Application Number: 2013-091 **Application Date:** 04/08/2013
CBL: 045 B023001 **Application Type:** Level III Site Plan Under 50,000 sq f
Project Name: Levell III Site plan/ Change of Use
Address: 91 STATE ST
Project Description: Renovation of existing building into 10 apartments. Change of Use from "convalescent home" to multi-family residential.
Zoning: R6

MEMORANDUM

Subject: Application ID: 2013-091

Comments Submitted by: Marge Schmuckal/Zoning on 5/7/2013

Alternative Zoning Map Amendment from R-6 to R-7

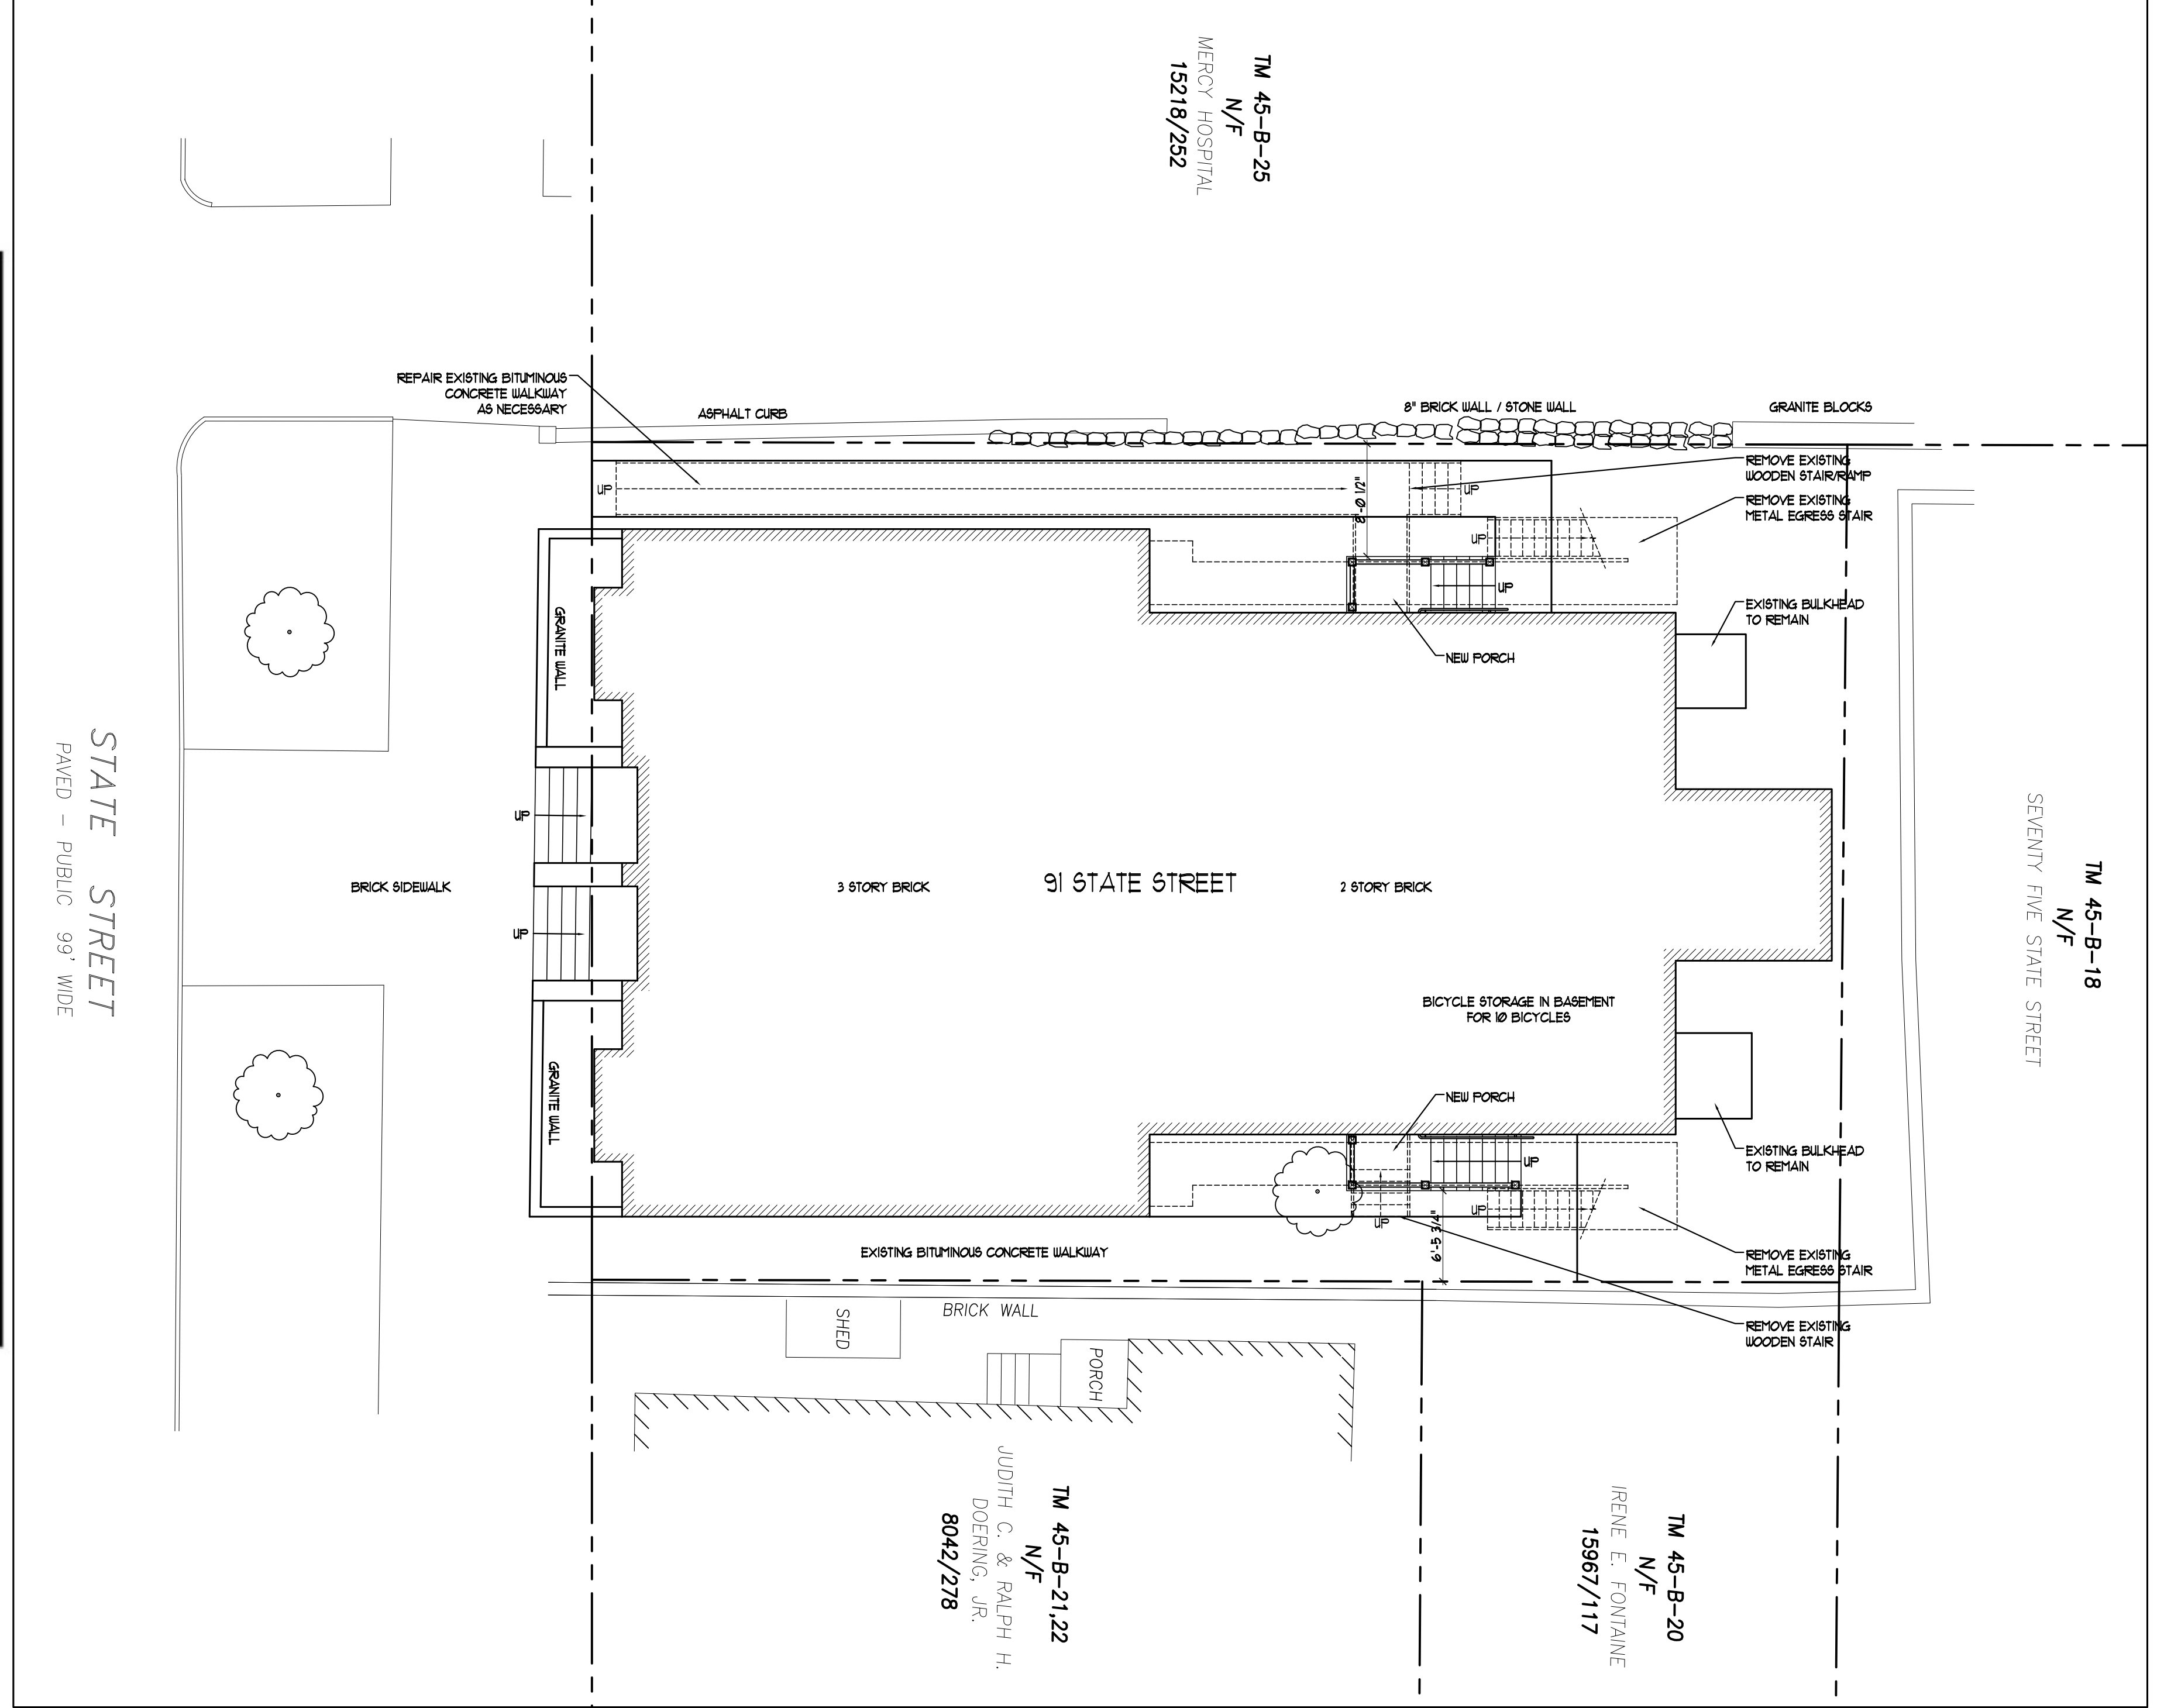
Today I received a revised plan showing that both side entrances will meet the R-7 minimum side setback of 5'. One is 8' the other is 6.5'. All the R-7 zoning requirements are being met.

ok for R-7
min setback

I have reviewed the most recent plans down loaded in e-plan. The latest floor plans confirm that the minimum 400 square foot for each apartment is being met. I have scaled the setbacks for the new porches. Section 14-142(a)3.b Of the R-7 Zone states that minimum setbacks for the side and rear is five (5) foot for each. My scaling of the plans show the Northerly side of the building to be less than 5' for a setback It would be in violation of the R-7 zone. The southerly side of the building shows a 6' side setback which meets the R-7 zone requirements. I would like the applicant to confirm the setbacks. There is no bar scale on the final site plan in which to completely calibrate dimensions. I acutally used the dlmensions of the building on the survey plan to calibrate on the final site plan. Again, I would want to see confirmation on the side setbacks. The minimum rear setback of 5 foot is more than being met.

This project is not required to show parking under the exemptions listed for historic districts. I have tried to review the new site plan. However, the submittal does not meet the requested format for review under e-plan. The plan does reveal that the plan is at 1/8" scale. There is no dimension on the plans for me to calibrate my measuring. I will need a plan with a measurement bar on it, or a specific dimension shown on the plans that I can use. There are a couple new entry ways being proposed for which I want to be sure are meeting the requirements.
